**PROPOSED RESIDENTIAL DEVELOPMENT, BERRY HILL ROAD, ADDERBURY (1899)
APPLICATION NUMBER 17/02394/OUT
RESPONSE TO HIGHWAY COMMENTS – FEBRUARY 2018**

This note will provide a formal response to transport and highways comments made by Oxfordshire County Council (OCC) in relation to the above planning application for residential development on land at Berry Hill Road in Adderbury. The comments were dated on 16th January 2018.

2M FOOTWAY/PED REFUGE WITH POTENTIAL BUS STOP @ 1:500 SCALE

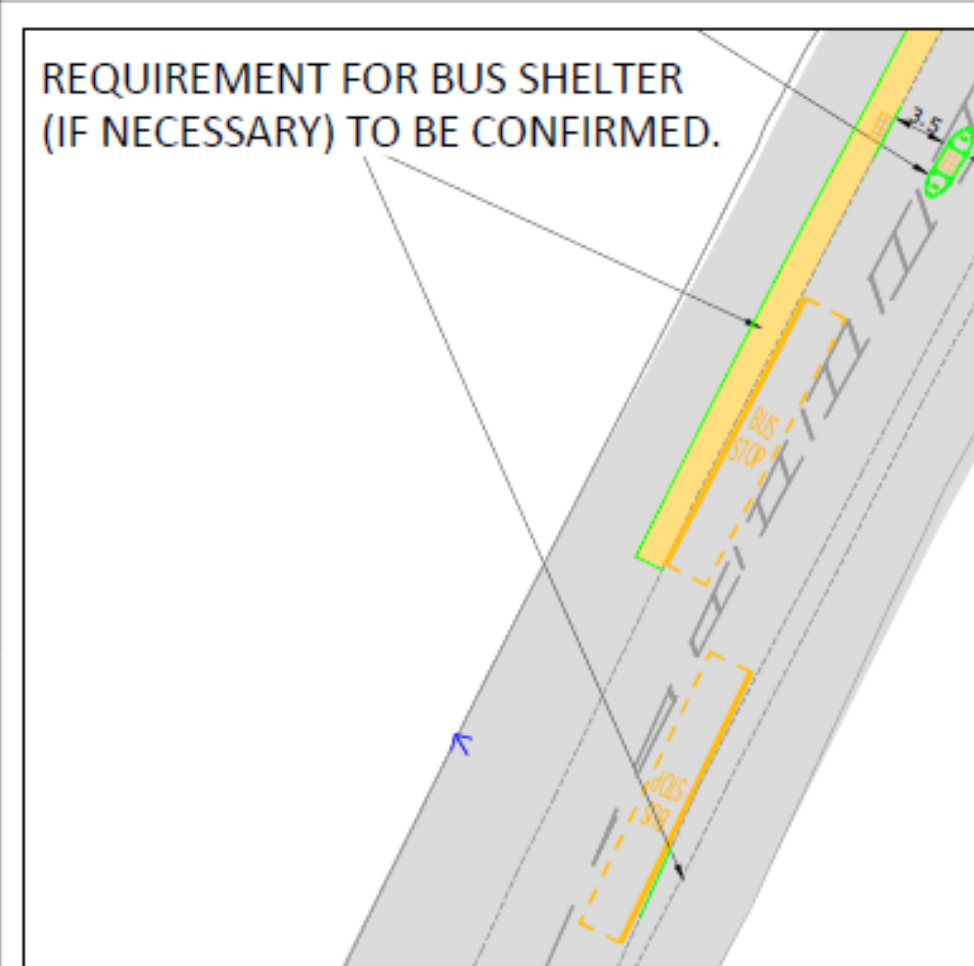
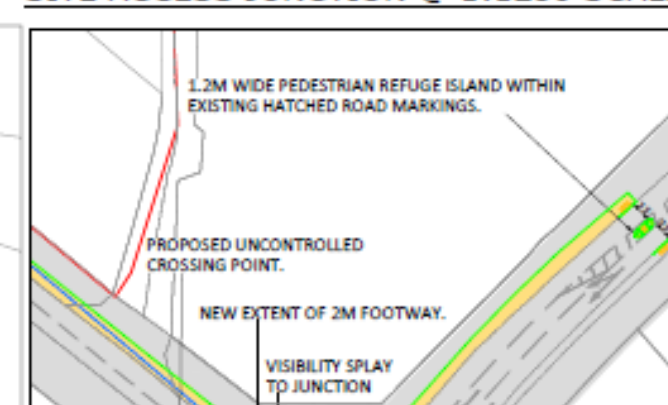
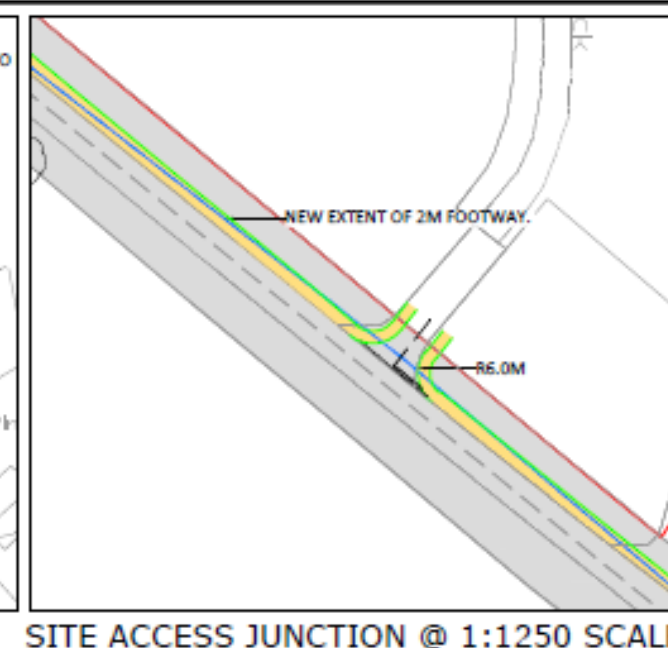
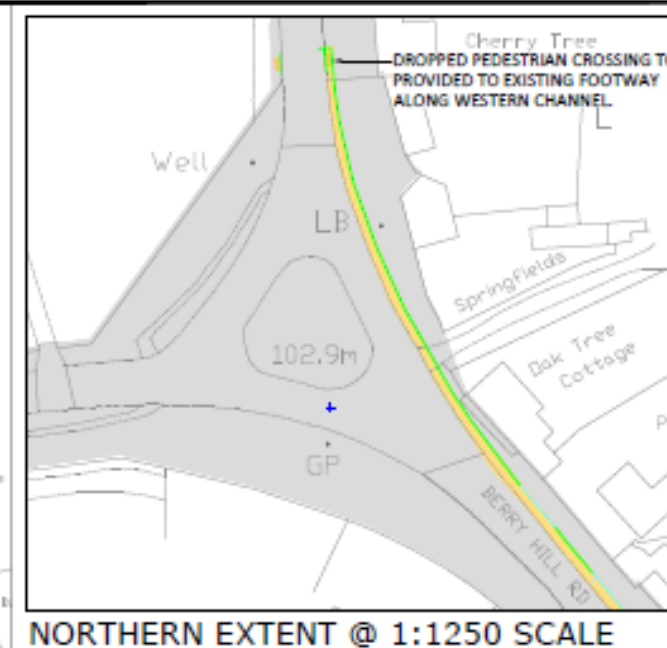
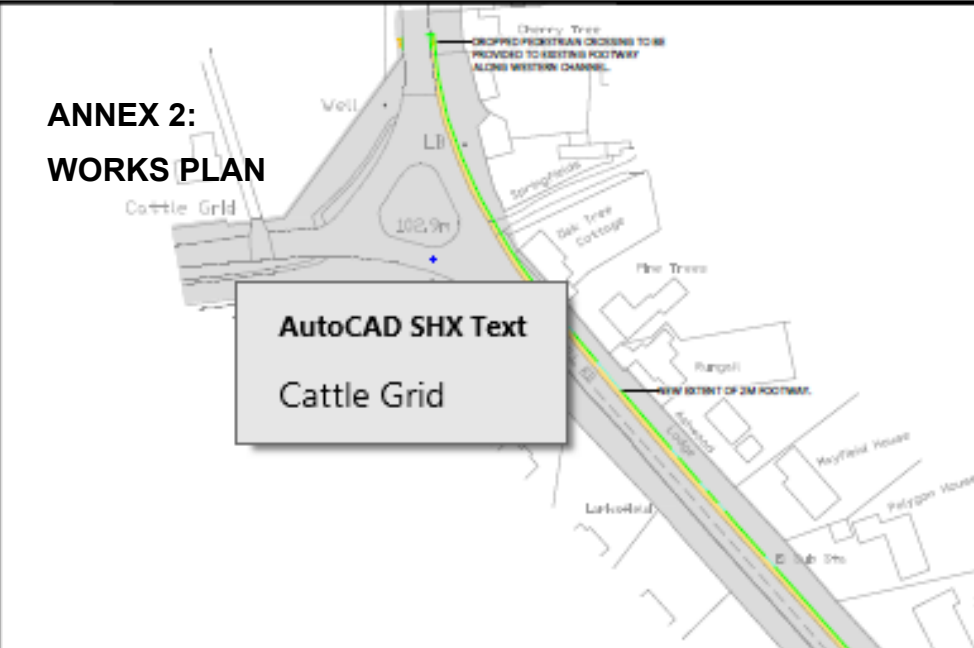
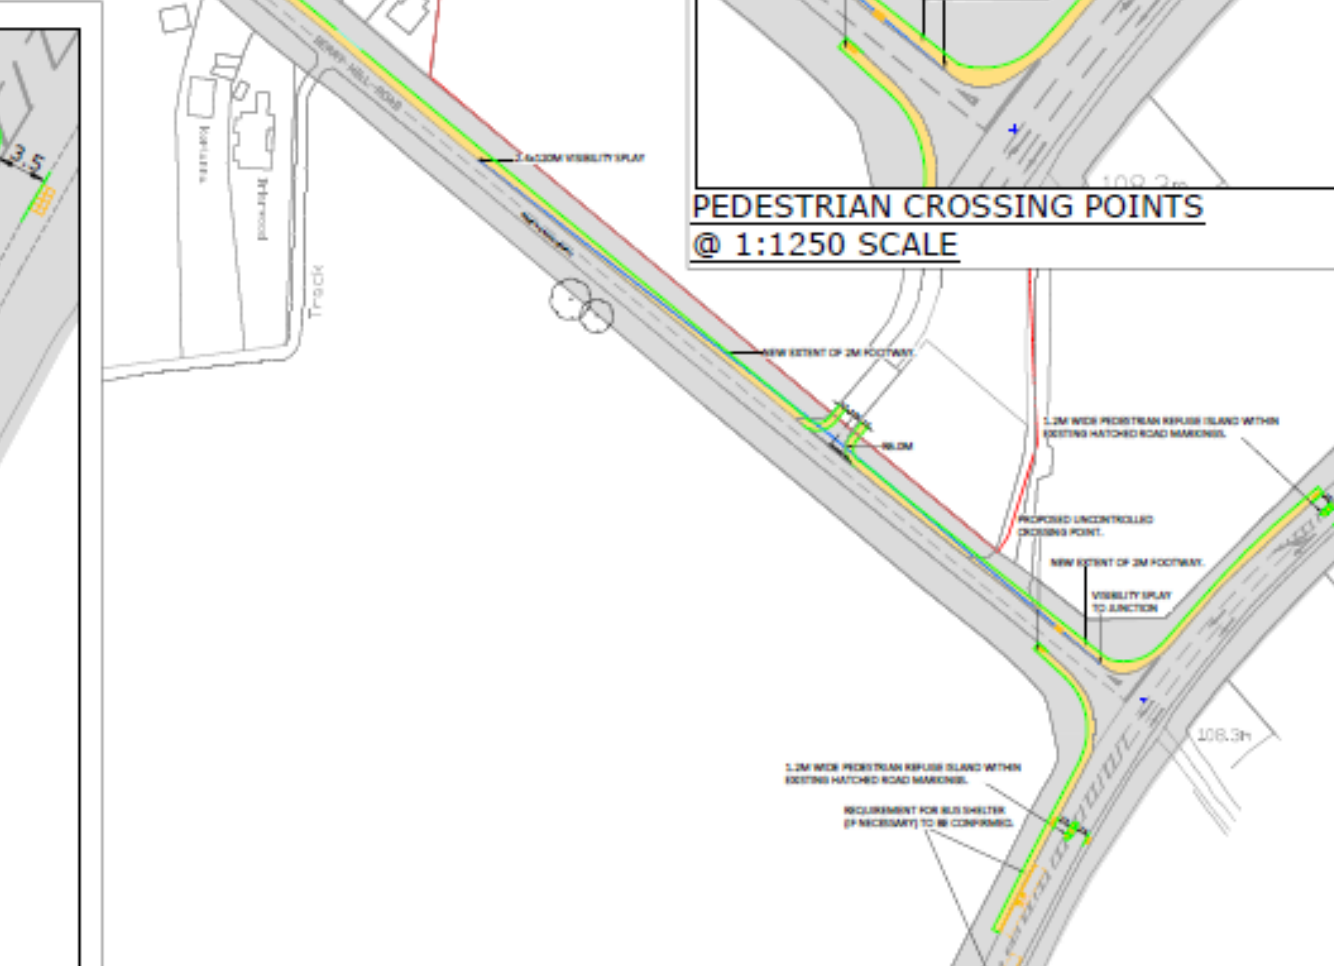
The applicant is proposing to implement a new footway along the northern side of Berry Hill Road to provide a direct pedestrian link between the site and the remainder of the village of Adderbury including the various amenities within the centre of the village. This link will clearly also assist the existing properties along Berry Hill Road in reaching the centre of the village safely and directly.

OCC have requested that clarification is added to the plan in terms of additional annotation. This has been done on the above mentioned plan and this can be conditioned as part of any consent at the site to ensure its delivery.

The proposed site access off Berry Hill Road is located close to the point where the 30mph speed limit changes to national speed limit. To ensure that the visibility splays at the site access junction are considered appropriate to OCC a speed survey has been undertaken at the point on Berry Hill Road where the site access is proposed. This is contained within **Appendix 1**.

These speeds would require visibility splays at the site access junction of 120 metres which are also based on the guidance within the Design Manual for Roads and Bridges (DMRB), as requested by OCC, rather than the more appropriate, in our view, Manual for Streets. These are shown on the Site Access plan on **Drawing Number 1899-Fo1 Revision A** and are shown to be achievable on land within the site or on adopted highway.

Drawing Number 1899-Fo1 Revision A shows a plan of the new footway which will be 2 metres in width and will be implemented via a Section 278 agreement which can be progressed if and when planning consent is granted at the site.

The grey shaded area on the plan shows the extent of adopted highway along the section of Berry Hill Road between Oxford Road and the junction with Horn Hill Road. The plan clearly shows that the new footway can be accommodated within the extent of adopted highway.
